From: [Bill Blanchard](#)
To: [Chace Pedersen](#)
Subject: Comment Re Egan Short Plat (SP-23-0001)
Date: Wednesday, March 29, 2023 4:25:16 PM

I am in strong opposition to Egan Short Plat (SP-23-0001). Sub-division of parcel #452836 will have a detrimental affect to our property, parcel #442836.

EGAN SHORT PLAT

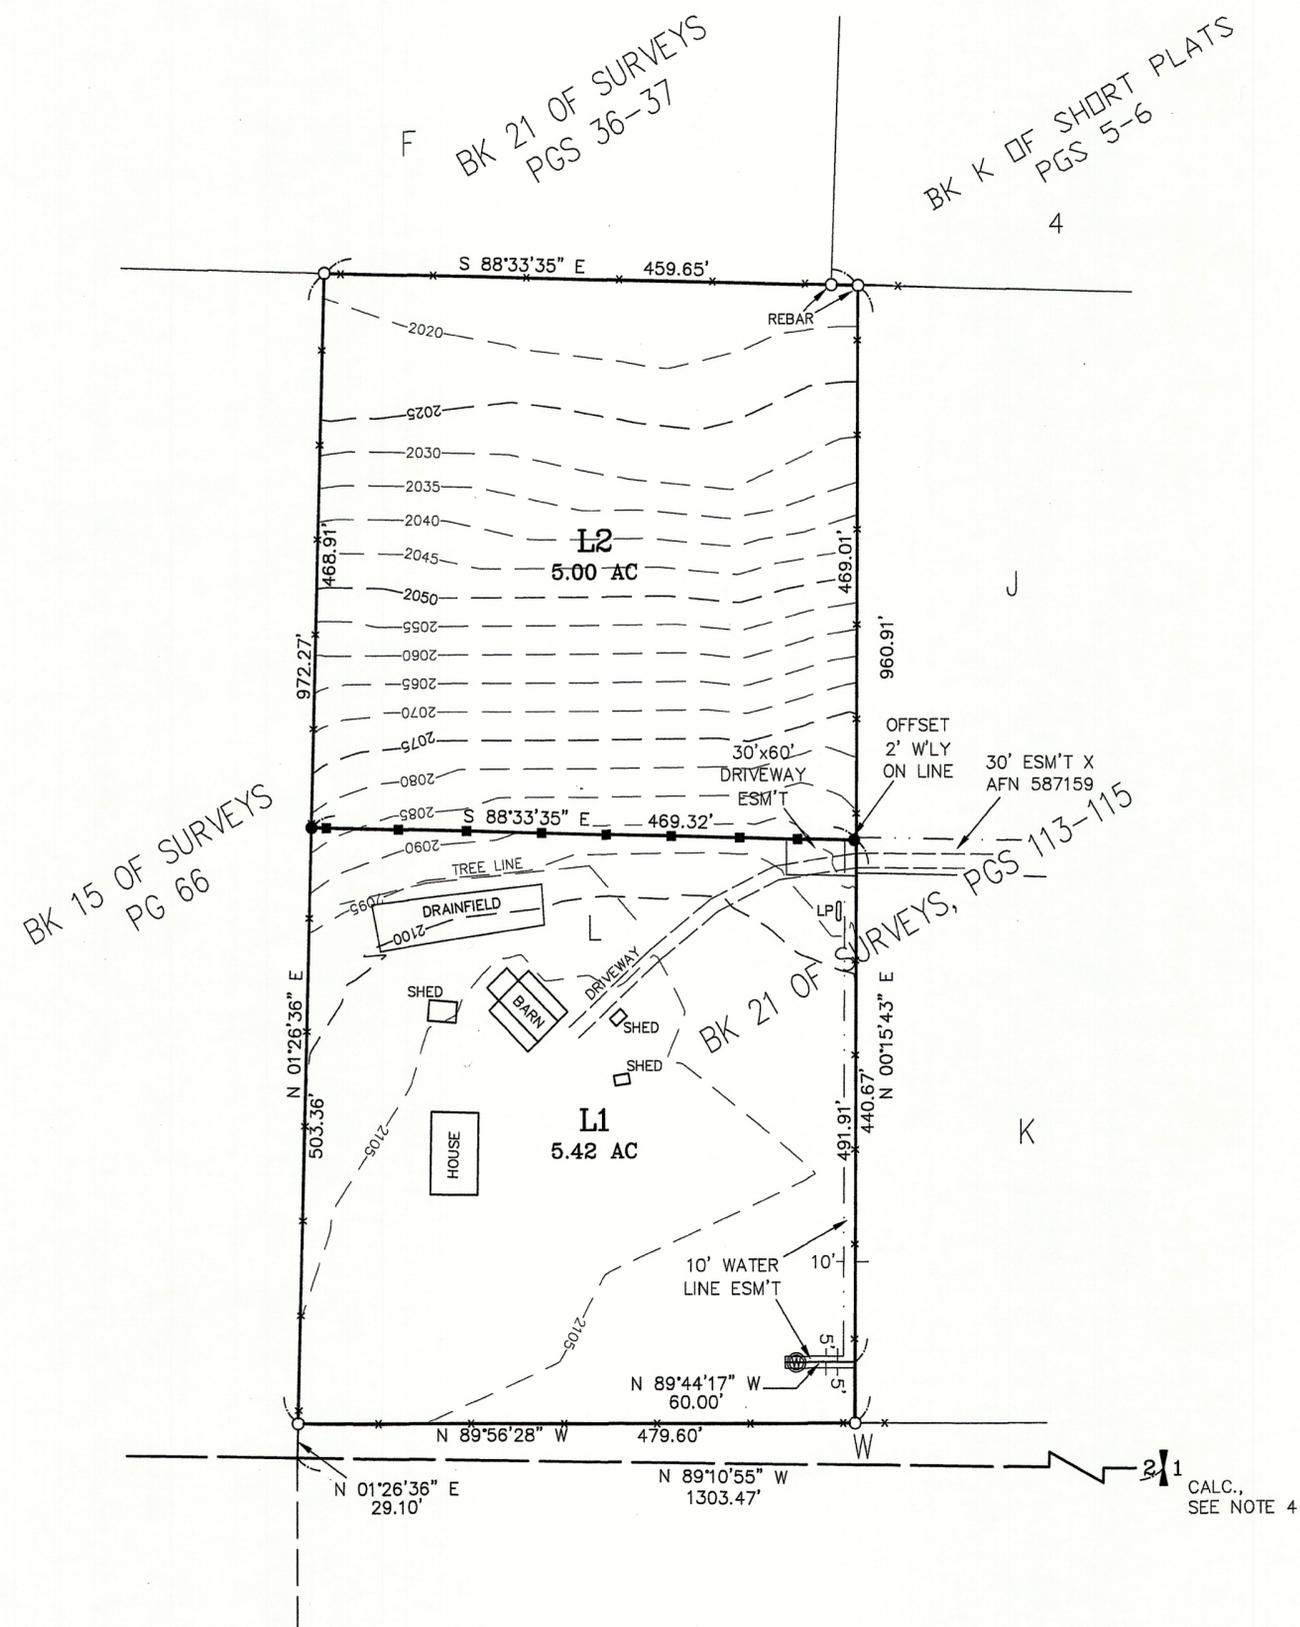
Current access to parcel # 452836 is limited to easement X as shown in survey recorded October 10, 1995 in Book 21 of Surveys, pages 113-115 under Auditor's File No. 586066 records of Kittitas County, Washington, Sections 1 and 2 in Township 19 North, Range 15 East, W.M., Kittitas County. The majority of said easement is on our property (parcel #442836).

This easement is currently utilized by parcels 442836, 655534 and 452836. It is the ONLY access to these three parcels and will be the ONLY access to the proposed sub-division. The easement is only composed of dirt and gravel with a hazardous, steep, and sharp blind corner at the southeast corner of our property. The full length of the easement road is already subject to washboard effect, deep potholes, and erosion due to constant wear from current traffic loads. Adding another plat will only increase this load.

Easement X road surface has only ever been 14 feet wide at most over its entire length since it was excavated in 1995. This is due to steep embankments on either side of the lower half, and a runoff ditch along one side and embankment of the opposite side along the upper half. This makes it impossible for vehicles to pass in opposing directions. Especially at the steep, sharp, blind corner (see accompanying photos). Increased traffic will also increase the likelihood of more frequent head-on encounters making travel for all parties affected awkward and difficult. In addition, winter conditions compound these difficulties, including access by emergency vehicles.

According to 12.01.090 of the Kittitas County Code, it is the responsibility of the developer to improve the "roads", in this case our easement, in accordance with KCC 12.10. Without the improvements made, we cannot agree to this subdivision.
